Cobalt Geosciences, LLC
P.O. Box 82243
Kenmore, Washington 98028

November 28, 2022

RE: Plan Review
Proposed Residence
6922 SE 33rd Street
Mercer Island, Washington

In accordance with your authorization, Cobalt Geosciences, LLC has prepared a plan review letter for the project. Specifically, this letter confirms that we have reviewed architectural sheet A10 updated November 2022 by Helix Design Build which shows a section through proposed wall and crawlspace footings in the eastern portion of the structure.

SHEET NO.
A10

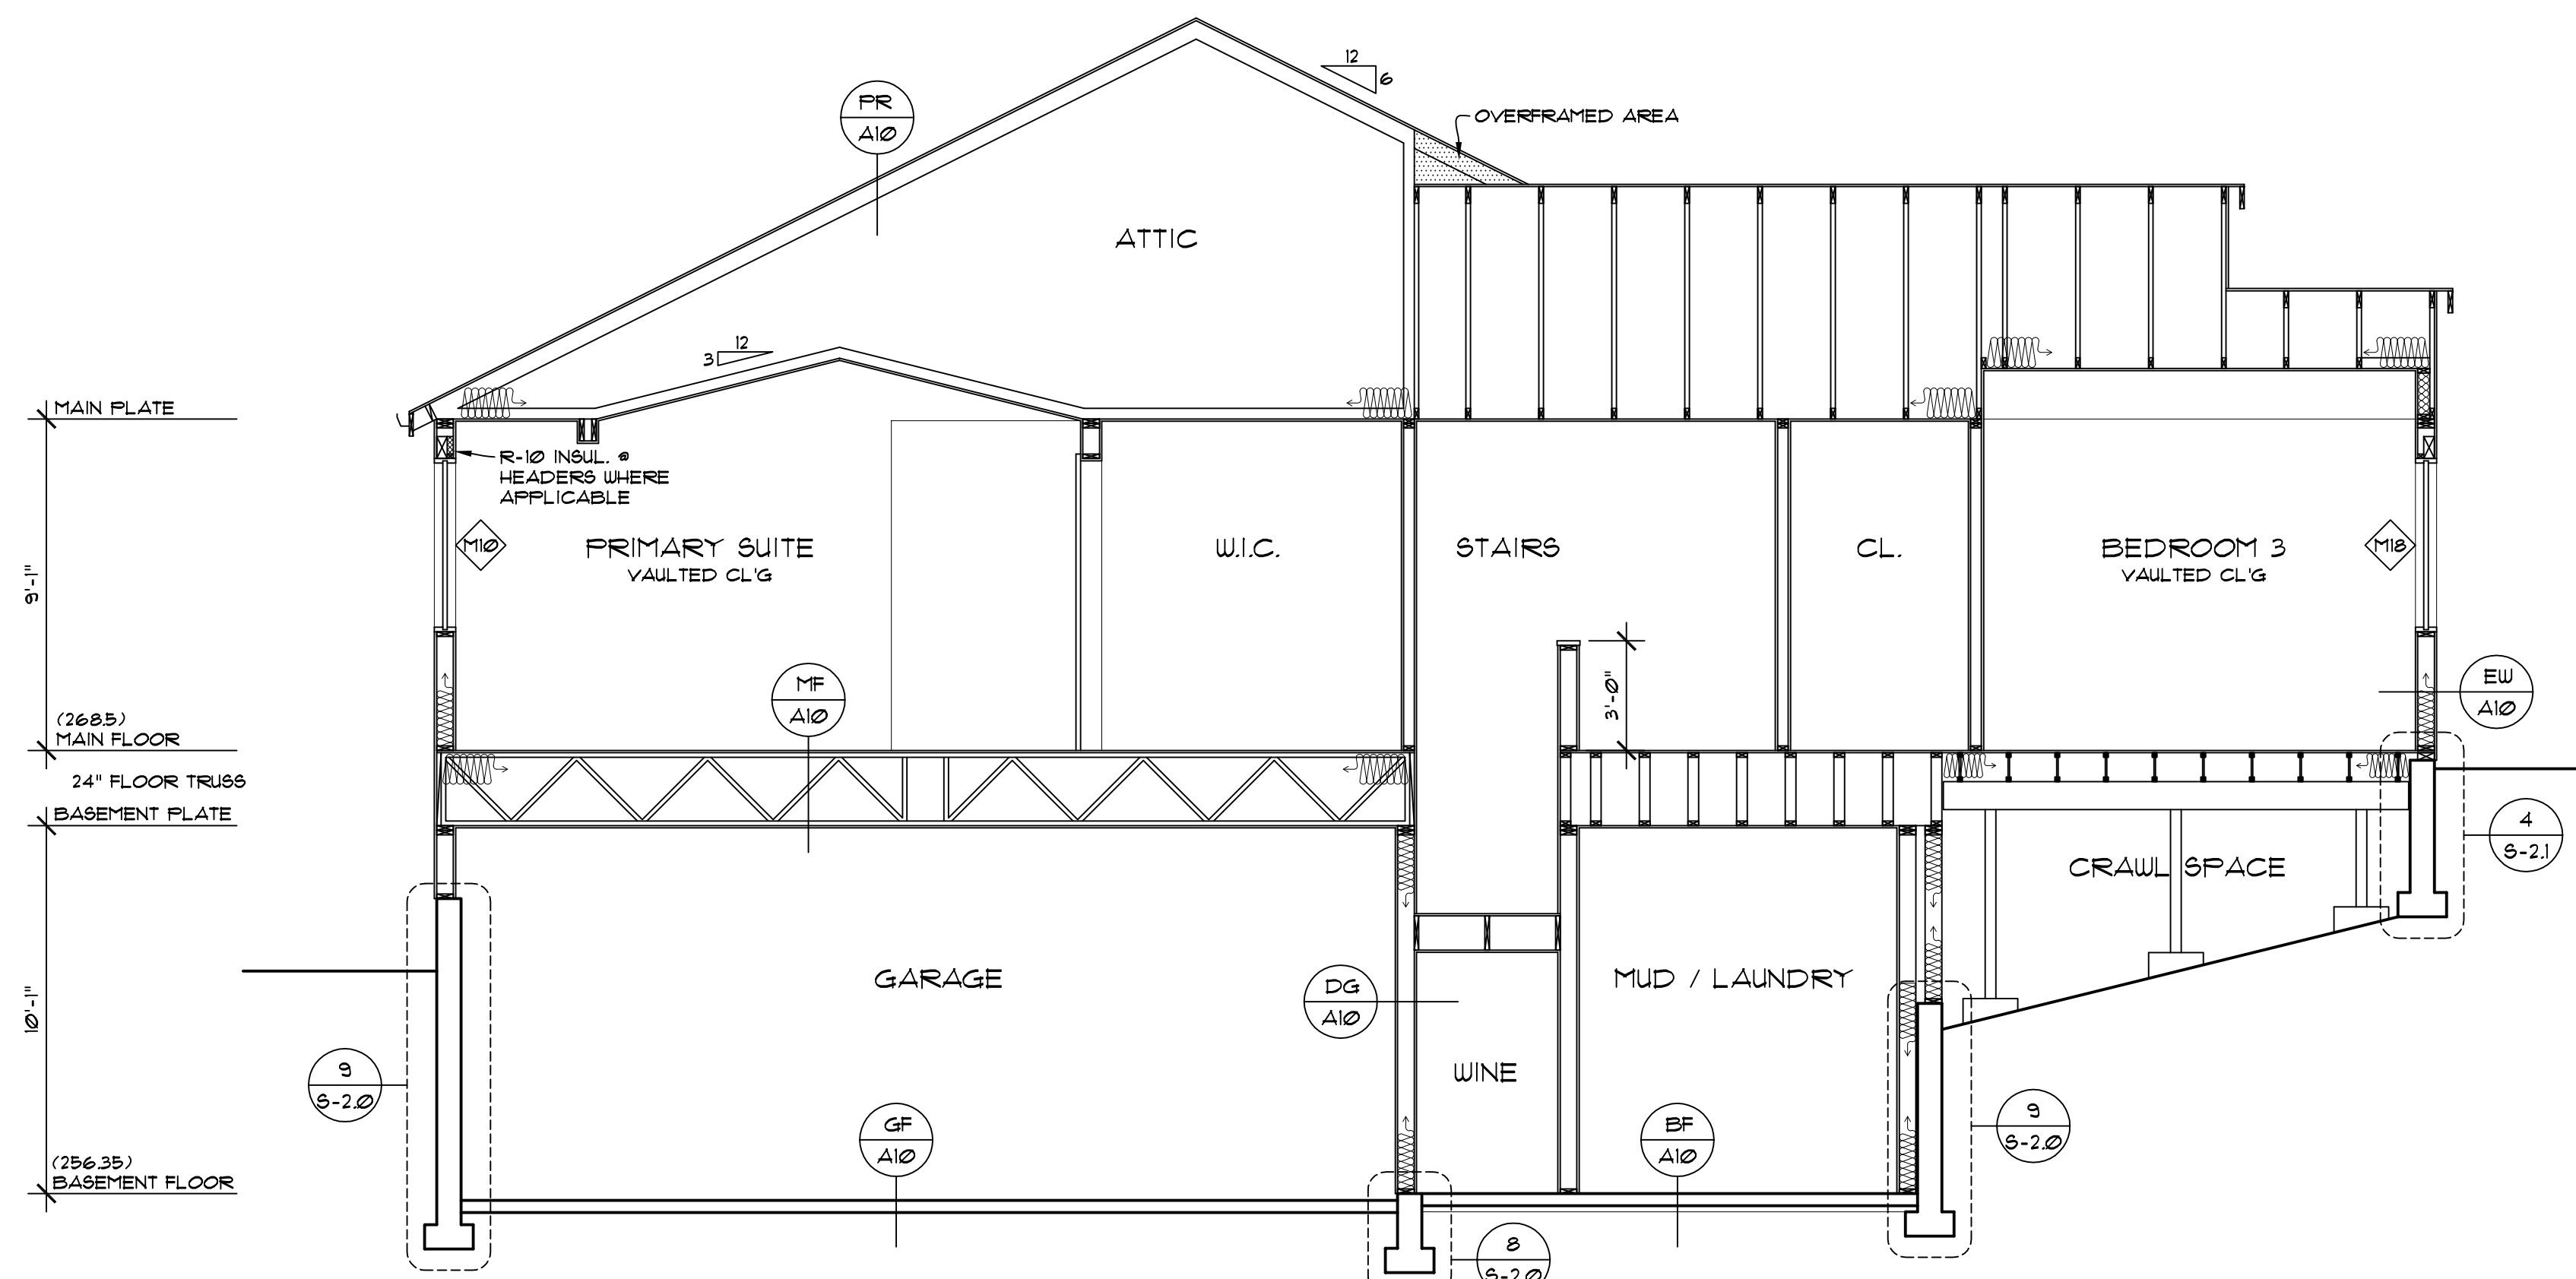
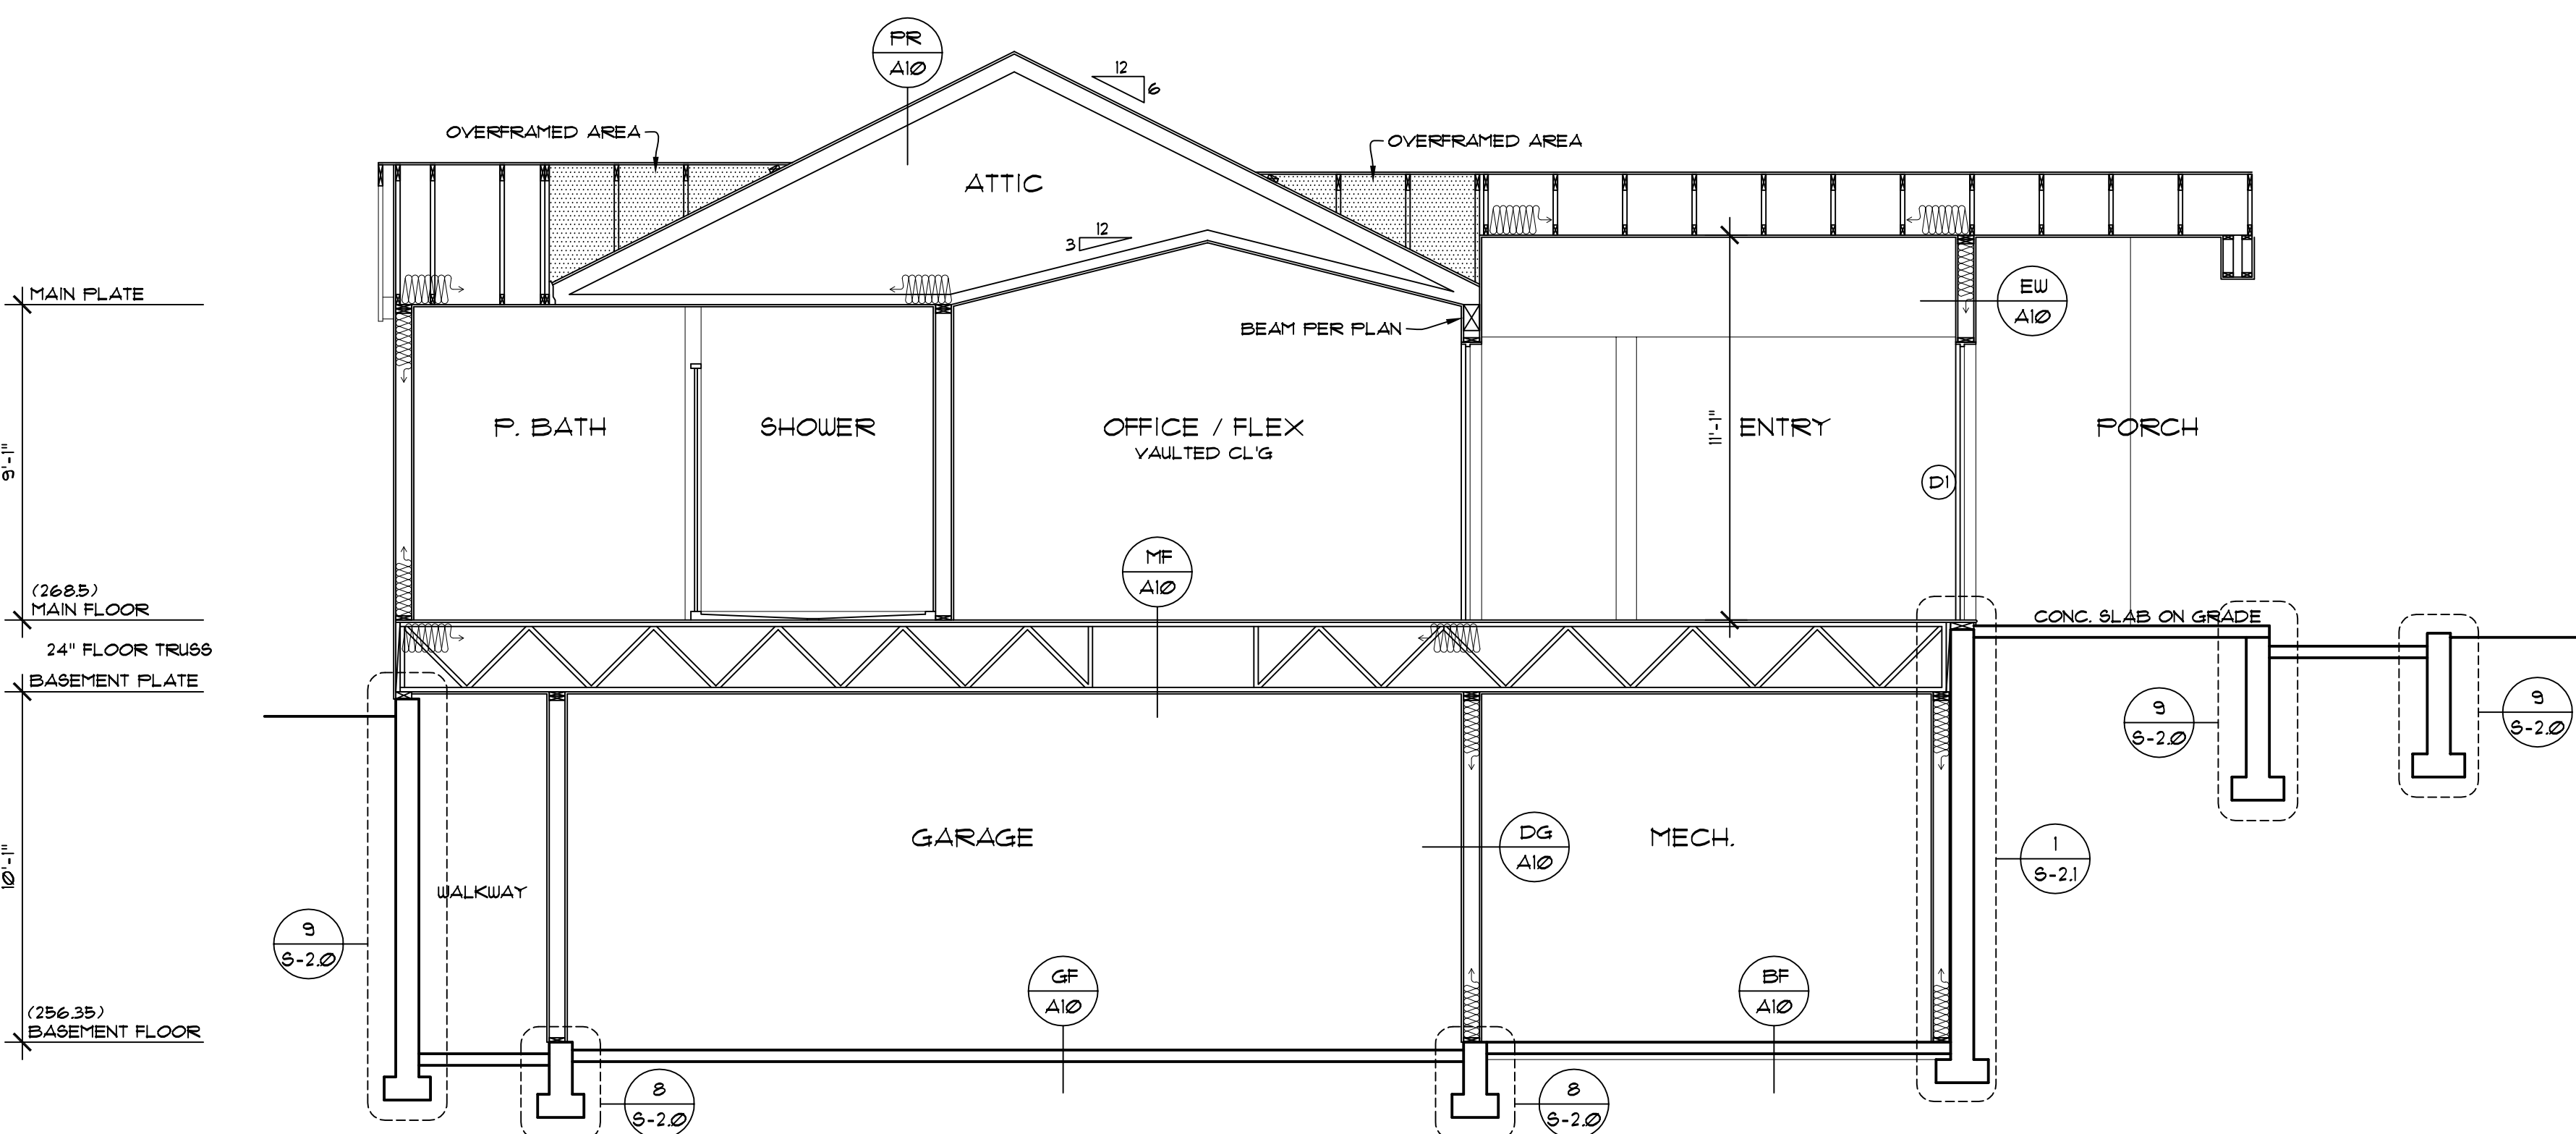
The updated layout results in a minimum 1H:1V envelope between the footings to result in no surcharge of upslope footings on downslope footings. The currently proposed locations and elevations appear suitable. We should verify soil bearing during construction.
